**From:** Sue Howell  
**Sent:** 20 February 2025 12:45  
**To:** Planning.Responses  
**Cc:** Jessica Riches  
**Subject:** Planning Consultation on: F/14/24/RES, F/15/24/RES, F/16/24/RES

### **Response to Planning Application**

**Application ref:** F/14/24/RES, F/15/24/RES, F/16/24/RES

**Location:** Land at Ford Airfield Ford

Reserved Matters Infrastructure Primary Street (Central)			
Status:	For Planning	Drawn by:	GP
Project Number:	180641	Scale @ A1:	1:500
Drawing Number:	TOR-RMIN-XX-DR-L-P-006	Checked by:	TF
		Date:	06/2024
		Revision:	B

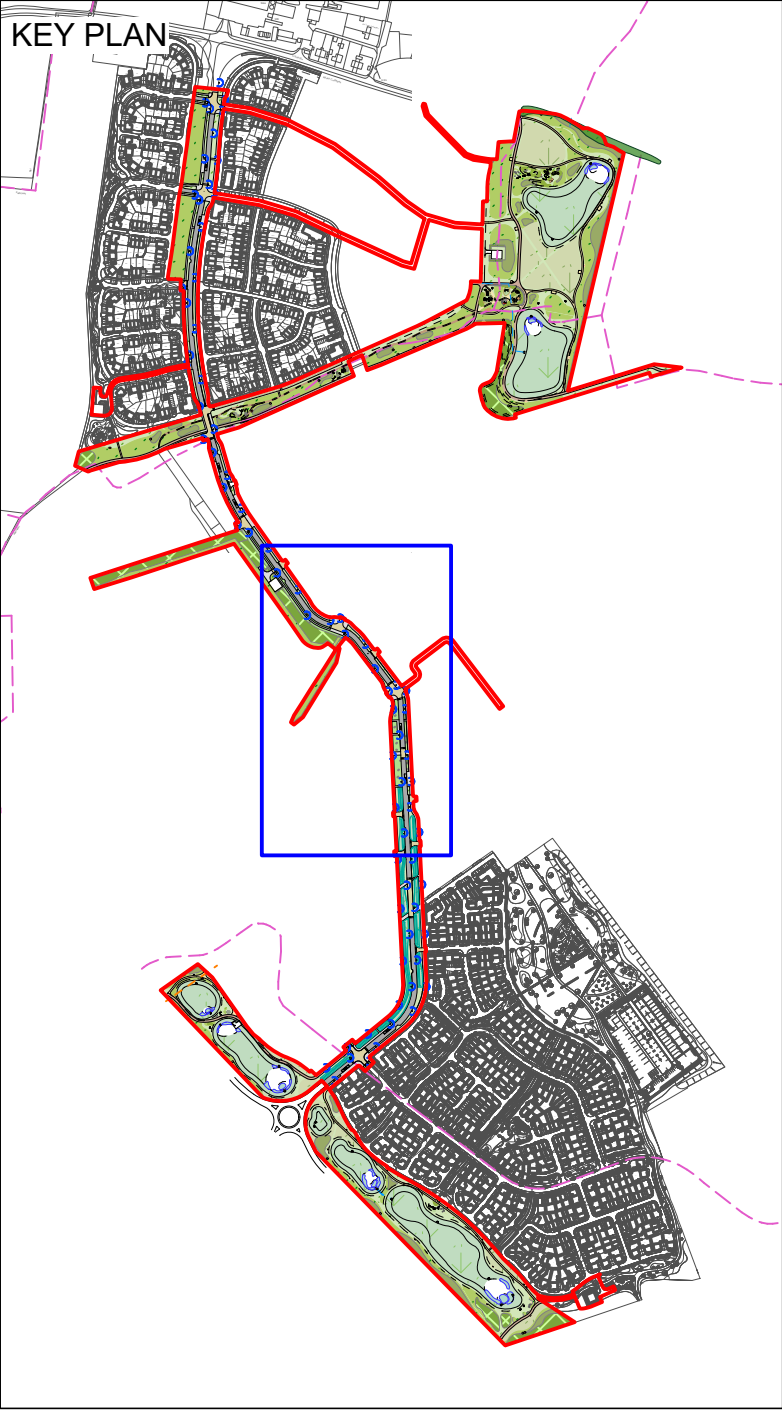
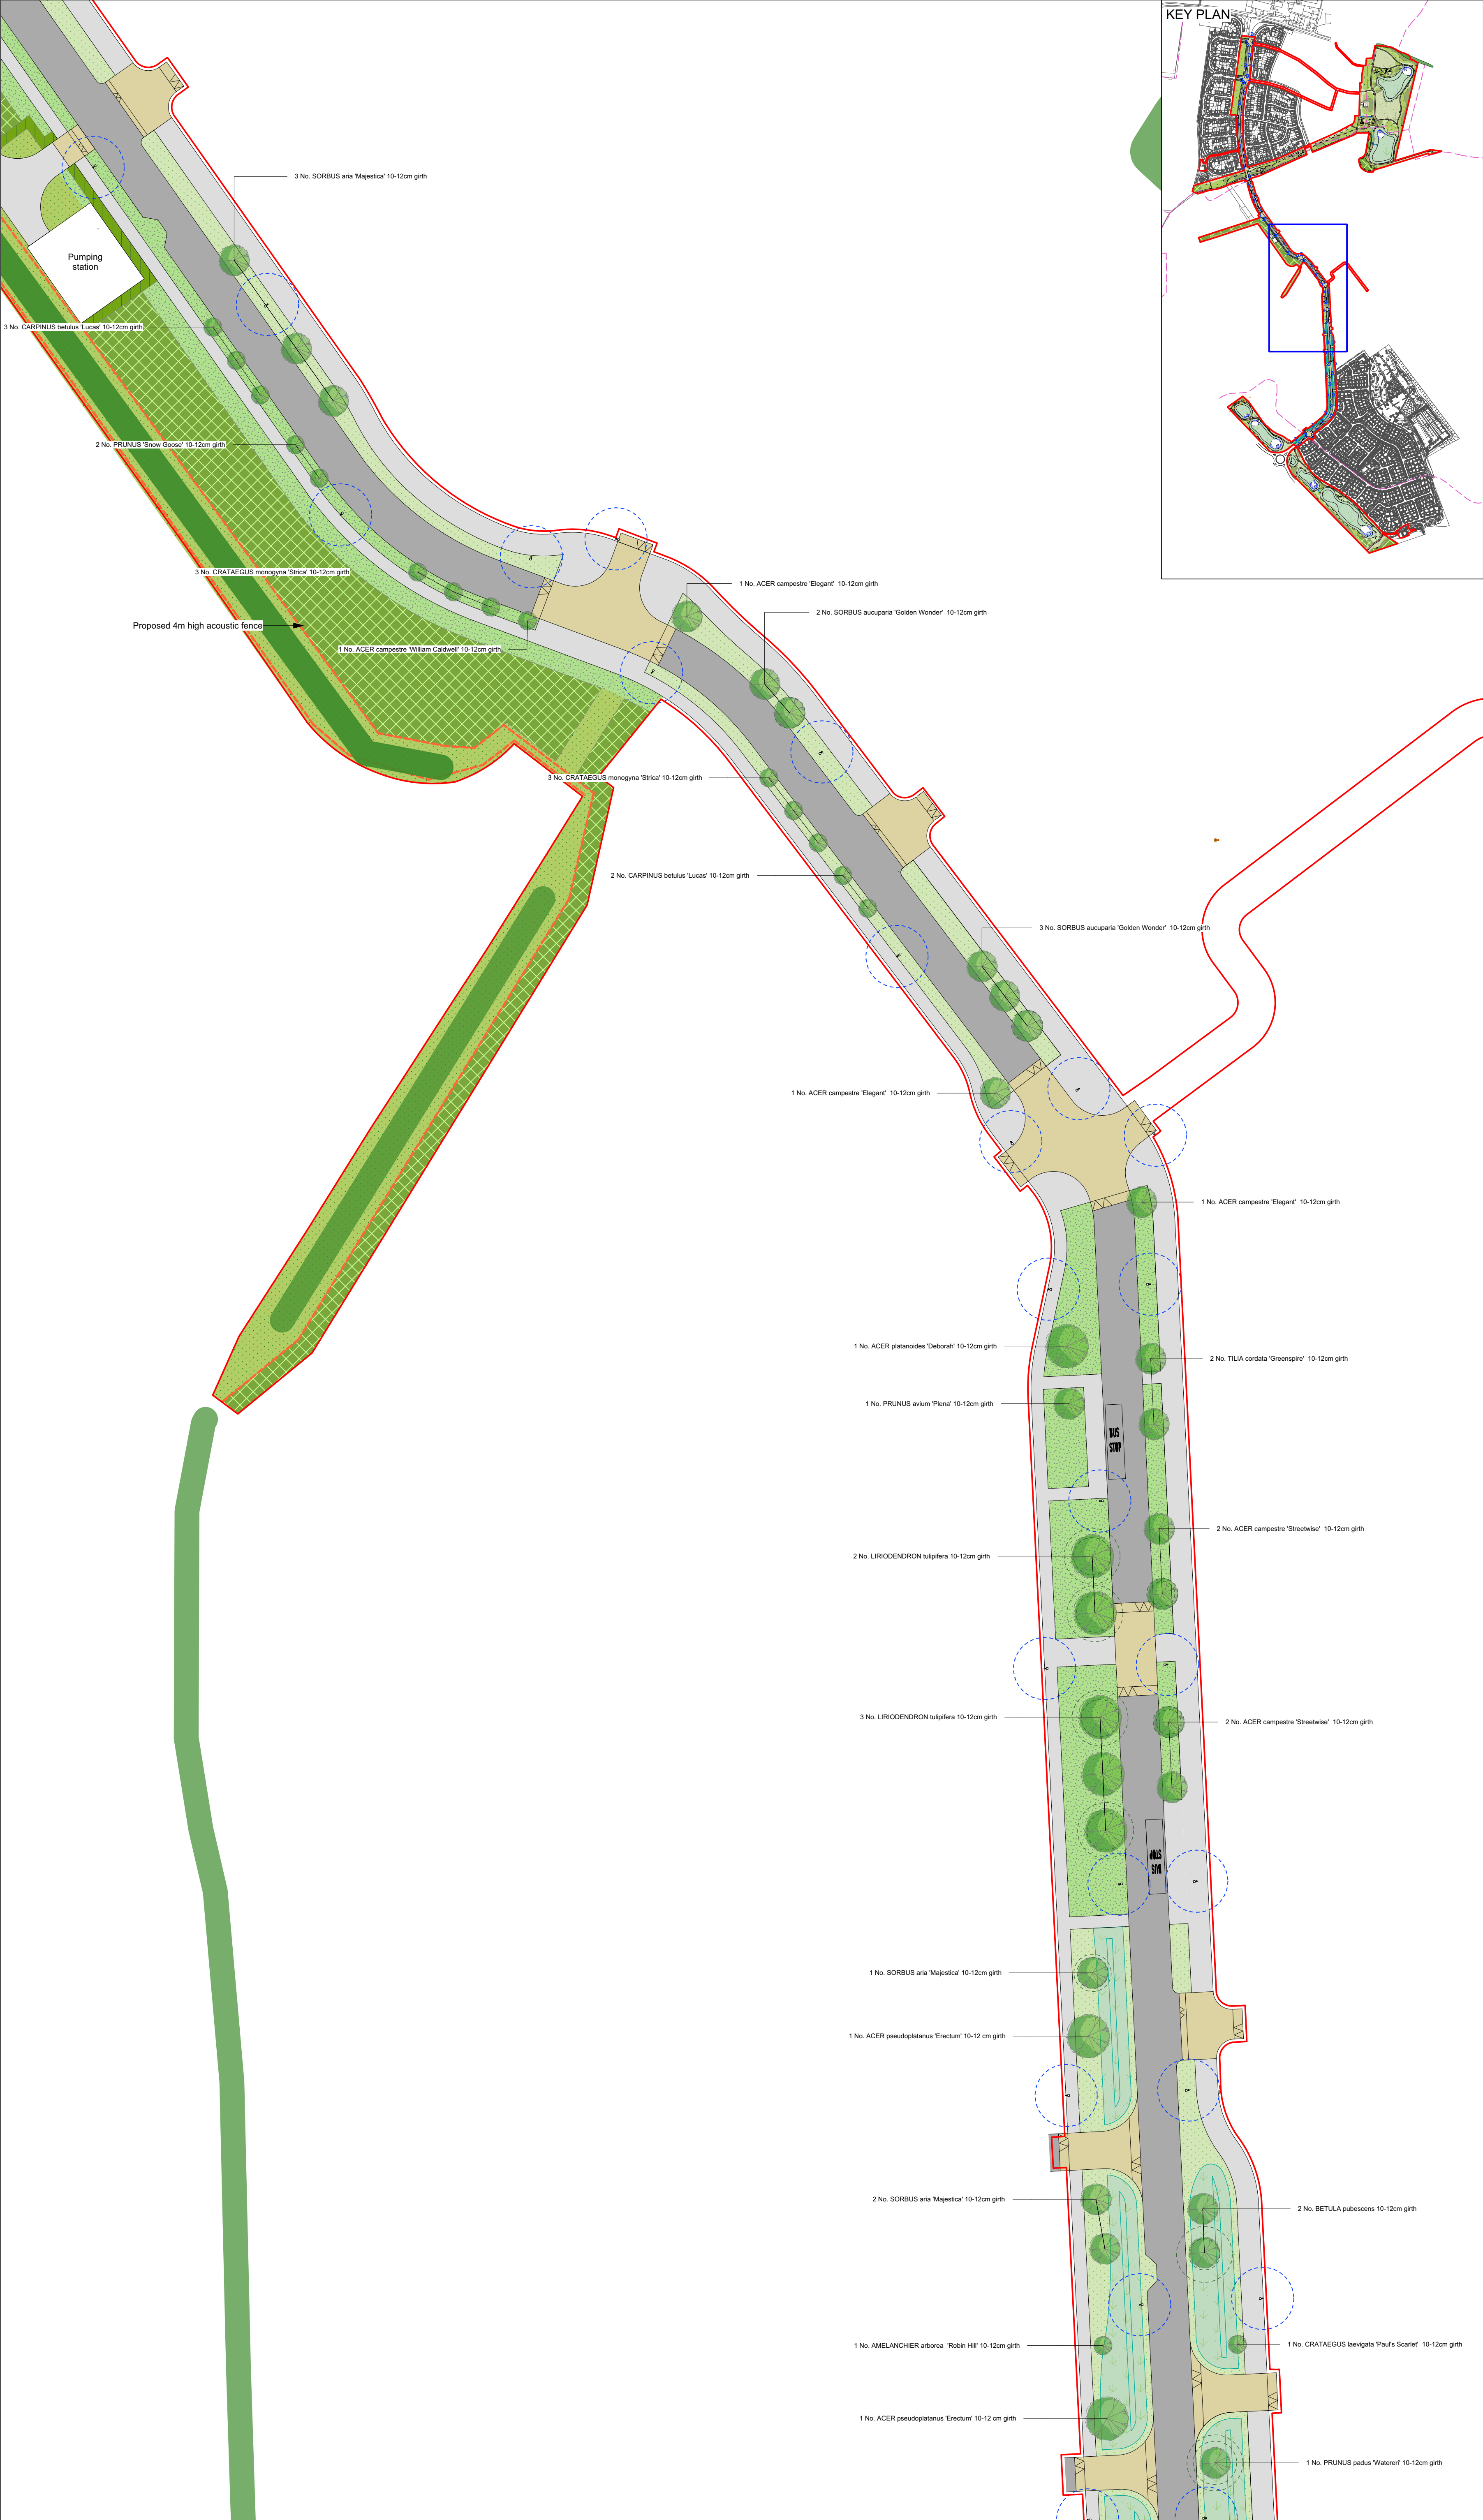
Trees positioned in swales or watercourse areas previously requested to be relocated. Street trees along the spinal road have been reviewed with limitations relating to visibility splays, lighting columns and drainage with the requirement for trees to be located 3m from the central channel of the swales.

As in the case of the canal, the spine road cuts through the line of the runway. This road and verge feature will interrupt the line, flow and visibility of the runway, and the proposed new area of open space which has been designed to reflect the shape dimensions and open character of this heritage asset. Essentially, rather than having one larger space, it will look and feel like two smaller linear parks. This is not positive and harms the impact that has been created through the retention of the runway. Ideally, the landscaping in this section of the road corridor should be informed by the runway. The result should be one long continuous green corridor along the route of the runway.

The runway / spine road crossing has been reviewed and now indicates the central footpath prioritised across the spine road in accordance with the Design Code. The section of road is on a raised table to aid in traffic calming crossing the runway and indicated by change of surface to block paving. Tree planting has been sensitively positioned to align to the runway corridor and are of medium species size to ensure strong visual links and open character are maintained running through the runway corridor. **Request** confirmation of what is meant by medium species size ie is this ultimate growth spec or size at time of planting?

Reserved Matters Infrastructure Ryebank Park 2 of 2

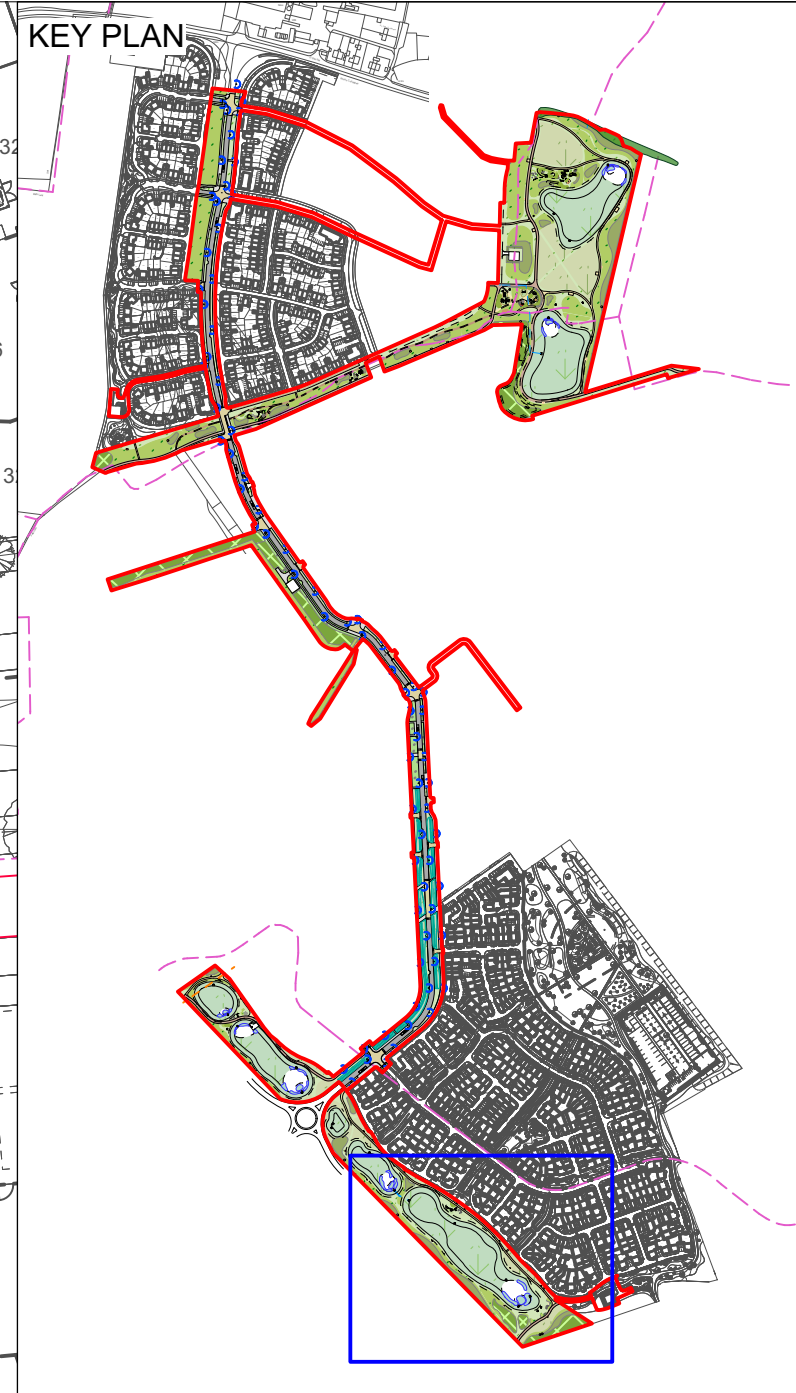
**Request** that Hardworks plans need to provide specification detail re seat, bins and street furniture proposed. Drawings presently say 'Timber seat' 'Timber bench' the street furniture palate needs to be uniform across the whole development.

Public Art & Interpretation Boards have now been detailed as *items identified on the landscape hard works drawings*. **Request** confirm where these are as not identified within the hardworks legends?
